Your reference: SSD-8873789  
Our reference: EF21/6995

**Advice on EIS and recommended conditions – State Significant Development – New Epping South Primary School (Concept and Stage 1) – SSD 8873789**

**Date:** 18 June 2021

Figure 36 Extract from AHIMS for adjacent PAD site (Source: Comber Consulting ACHAR)

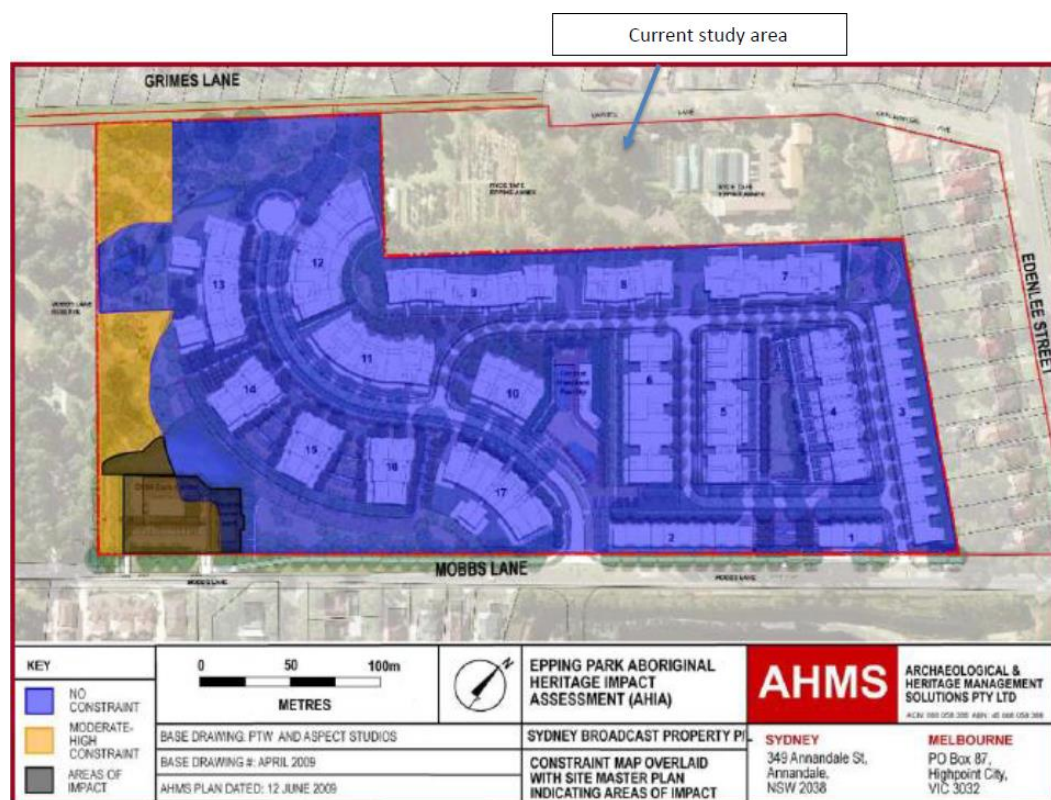
- a) The test excavations did not conform to the Methodology supplied to the RAPs and Heritage NSW on the 4<sup>th</sup> December.
- b) The ACHAR and Archaeological Assessment Report (AAR) do not contain information the reasoning for the test pit locations other than they were placed near geotechnical trenching. Requirement 16a of the *Code of Practice for Archaeological Investigation of Aboriginal Objects in New South Wales* (DECCW 2010) and Test Excavation Methodology both state that the test excavation units be placed in a systematic grid, this did not occur; and
- c) The information provided in the ACHAR does not make it clear if, following the current test excavation, whether PAD 1 of AHIMS site #45-6-3868 is still considered a PAD or whether further test excavations for required.
